PORTLAND MAINE

CBL: 047 A015001
Located at 779 CONGRESS ST

November 8, 2007

An evaluation of the above-referenced property on 11/07/2007 shows that the structure needs the following corrections **BEFORE** the permit for legalization (permit# 061698) can be issued.

MOORE STAIR DETAIL

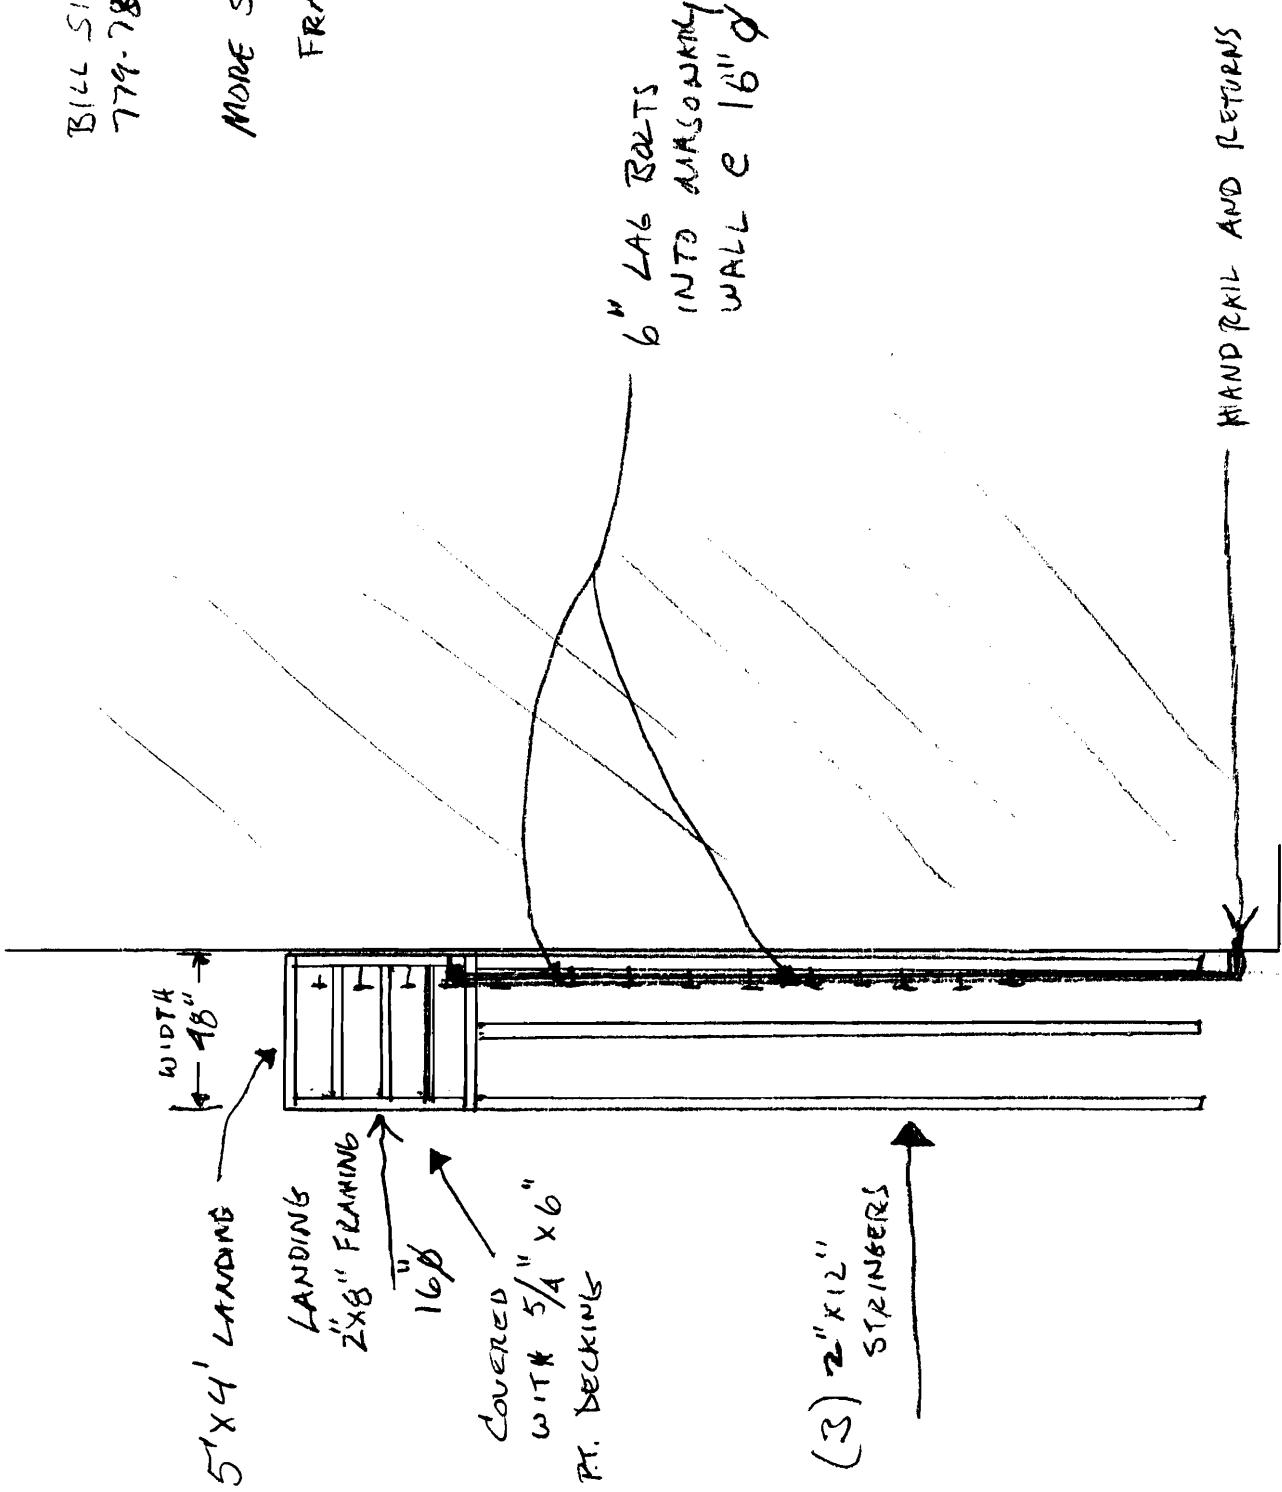
- 1) Wiring 3rd floor hallway needs to meet code
- 2) Smoke detector heights checked, ART.#5.7.3.2.1.-NFPA
- 3) Exit & Emergency 2nd floor
- 4) Rear stairs (last step) need platform
- 5) Outlet for washer machine replace
- 6) Furnace switch replaced
- 7) Cover boiler room control
- 8) Fire Door basement left door (781side)
- 9) All doors need to be numbered
